From: Liz Rogers [REDACTED]
Sent: 03 April 2019 11:07
To: Planning.Responses
Subject: RE: Planning Consultation on: FP/64/19/PL

App No: FP/64/19/PL

Address: Mow Cottage Worms Lane Felpham

Proposal: Replace burnt down cottage with a similar sized single storey property - This is a Departure from the Development Plan

SITE PLAN 1:500 @ A3

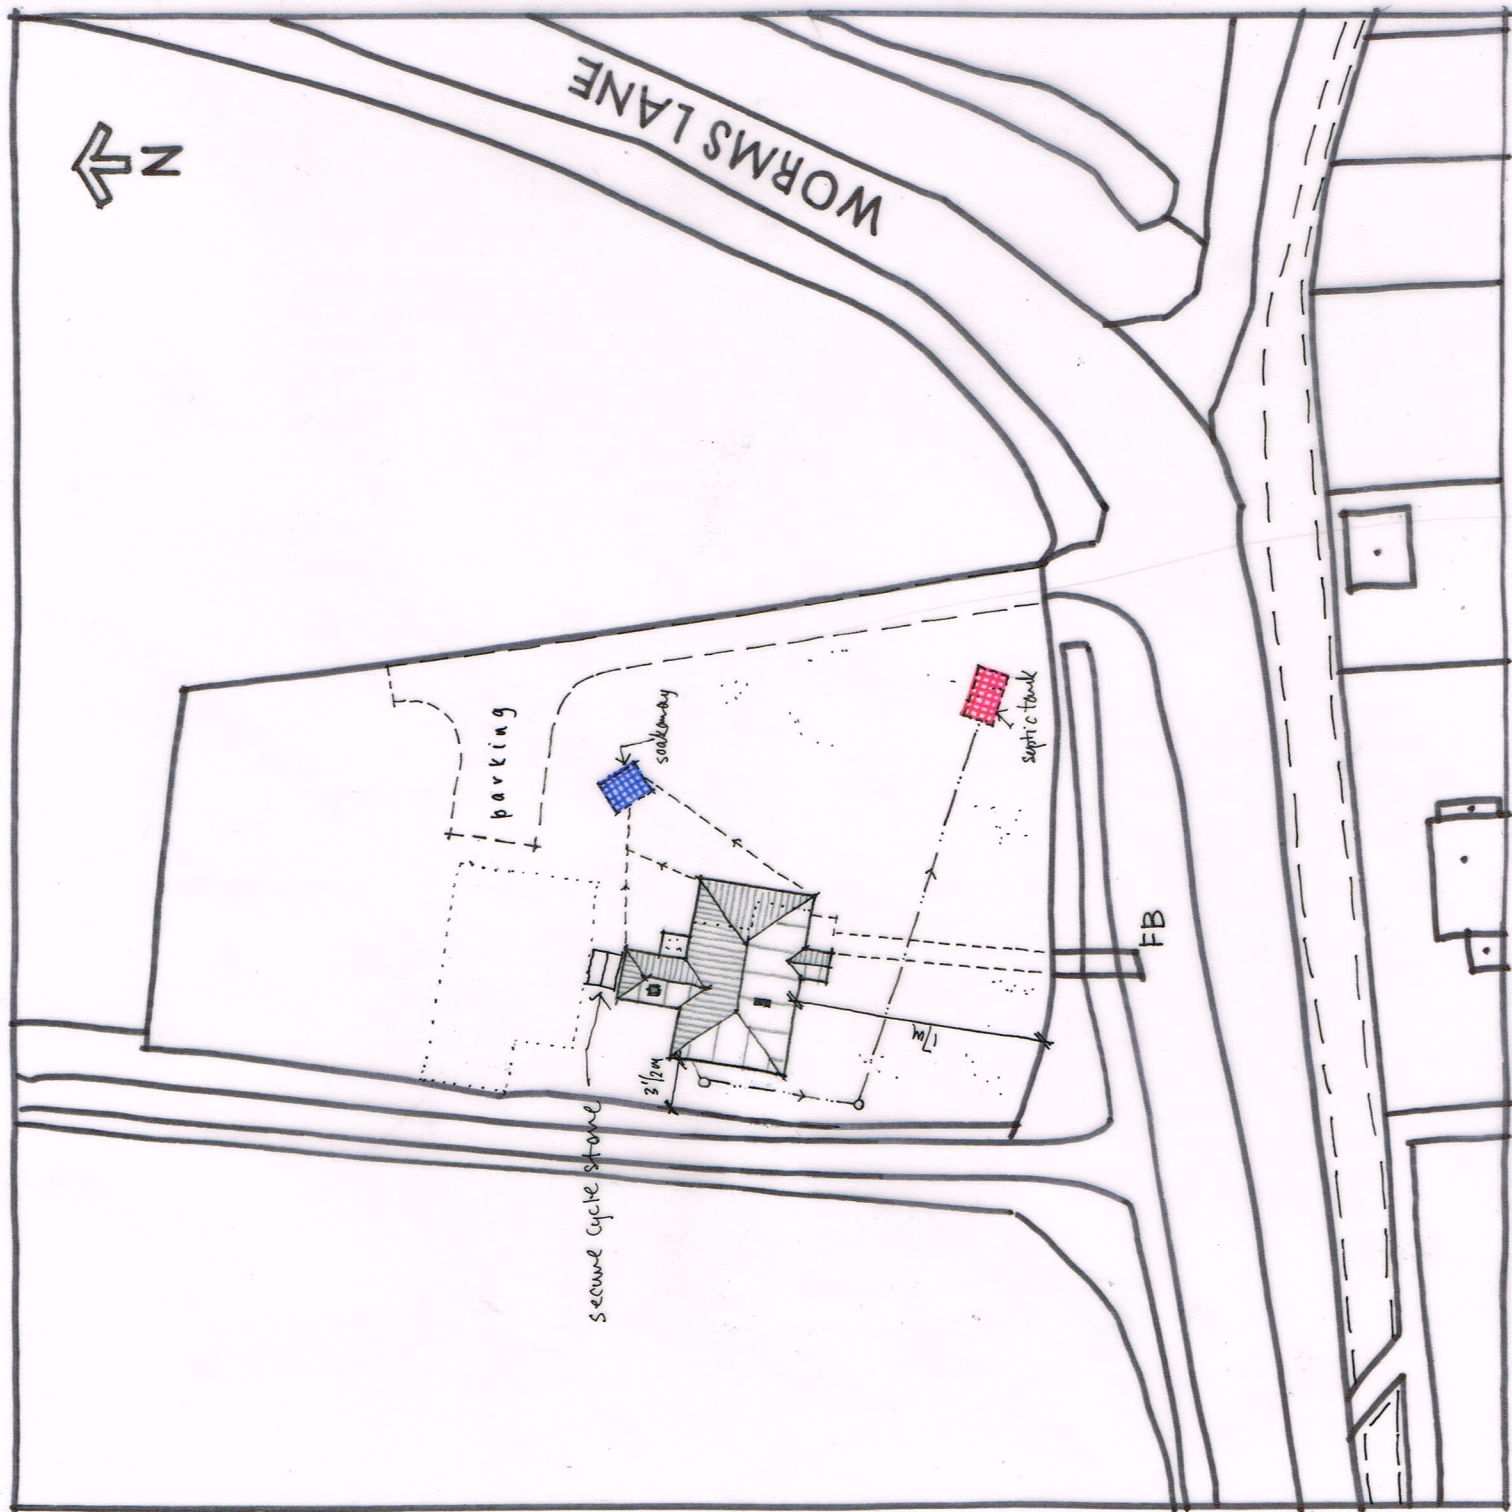
Due to the potential for roosting bats within the trees onsite, no works can take place to the trees and protection zones will need to be placed around these trees. Current plans show no works to the trees onsite, however if this changes then emergence surveys for bats would be required, and these survey reports and any subsequent mitigation strategies would need to submit to us as part of the planning application prior to determination.

The hedgerows and scrub on site are suitable for dormice and must be retained and protected from harm. This will include having a buffer strip around the hedgerow and scrub (5m) and during construction fencing should be used to ensure this area is undisturbed. Any gaps should also be filled in using native hedge species to improve connectivity. Conditions should be used to ensure this. If this is not possible dormice surveys will be required on these areas and these survey reports and any subsequent mitigation strategies would need to submit to us as part of the planning application prior to determination.

Due to the potential for dormice to be within the ditch adjacent to the site no works can take place within this ditch or vicinity and a 5m buffer should be set up from the ditch bank and fencing used during the construction period to ensure this area remains undisturbed. If this is not possible then further survey work for dormice will be required. These survey reports and any subsequent mitigation strategies would need to submit to us as part of the planning application prior to determination.
